EL PASO COUNTY GRADING AND EROSION CONTROL PLAN CHECKLIST

EPC Project Number: **PPR2417**

VTC Detail: Replace with EPC approved VTC detail (VT-1 and VT-2 in DCMV2, Chap 3.3) or revise to be 75ft min length.

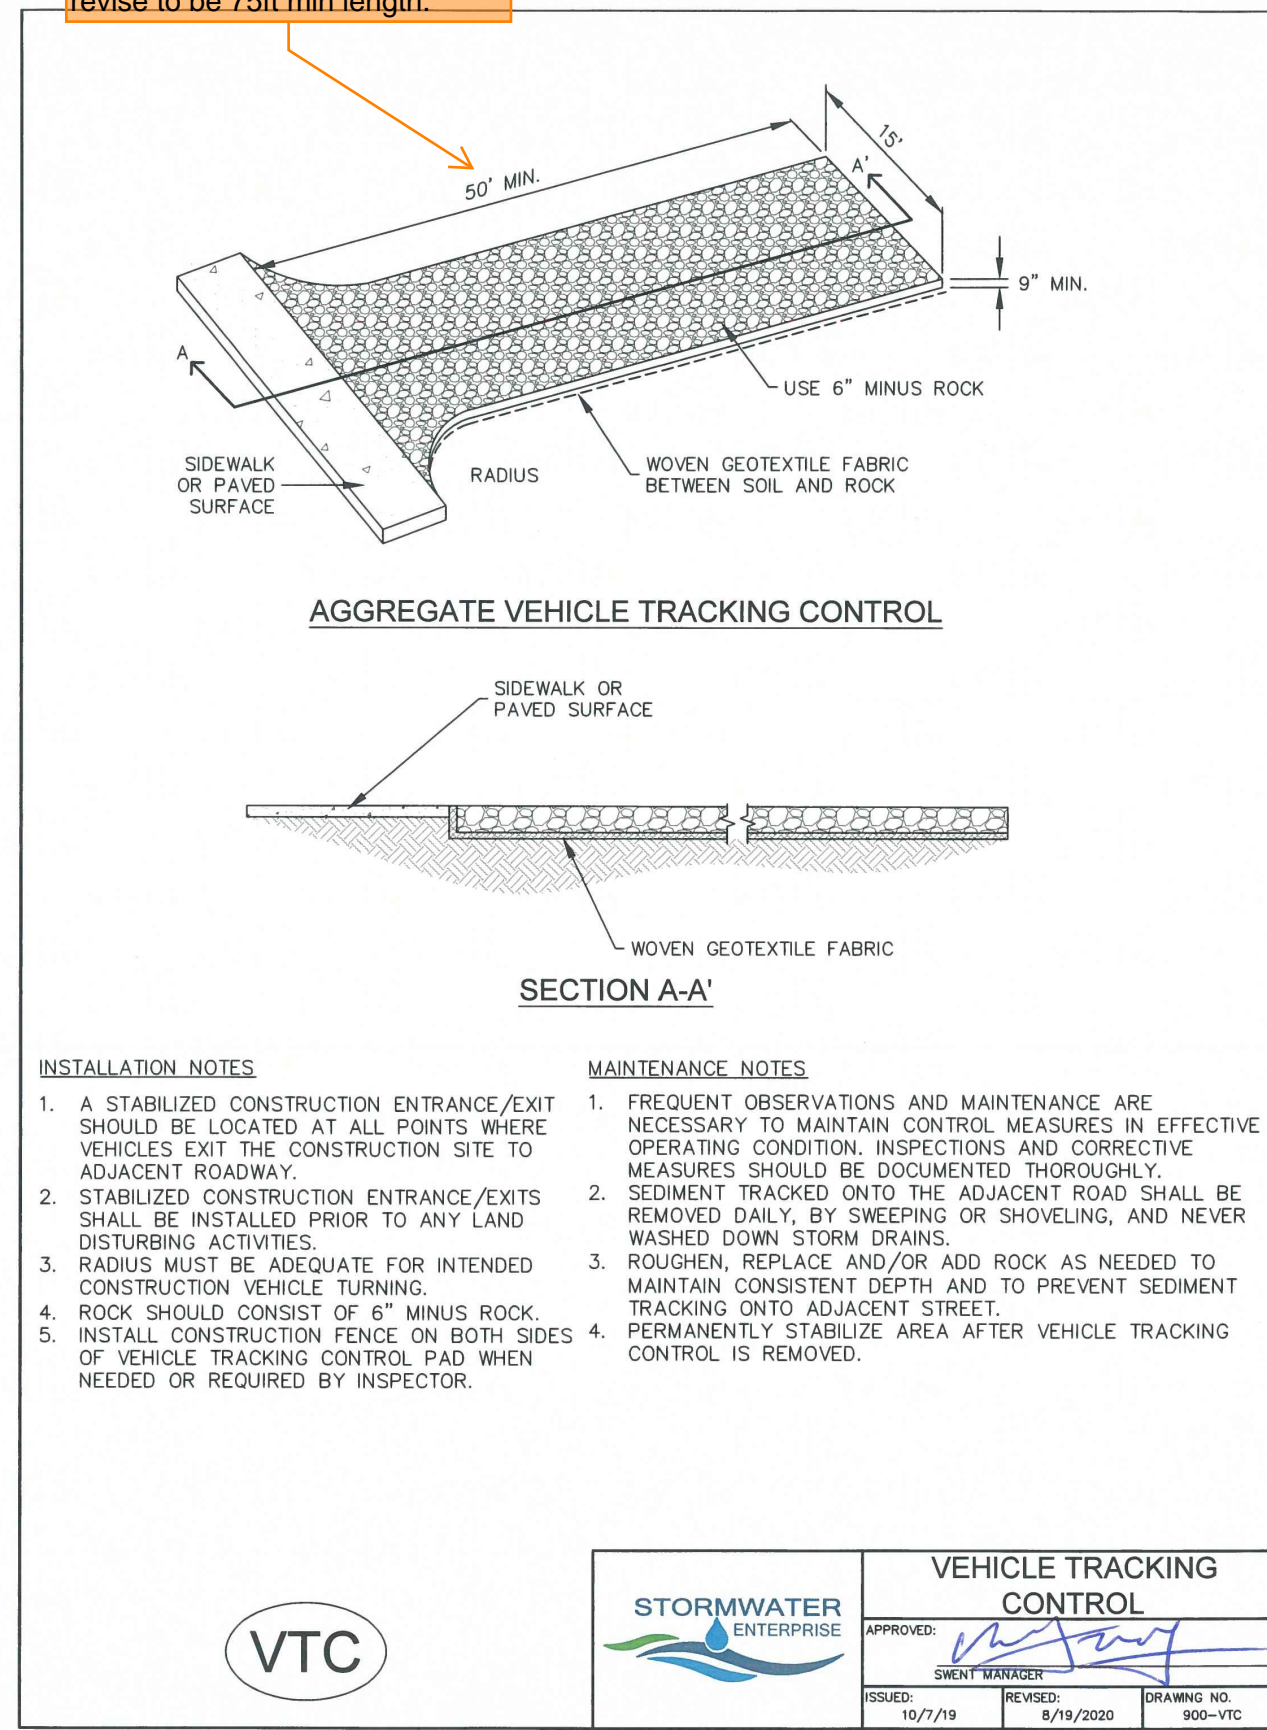
| | | Applicant | EPC |
|----|--|-----------|-----|
| z | All proposed temporary construction control measure details. Custom or other jurisdiction's details used must meet or exceed EPC standards | | N |
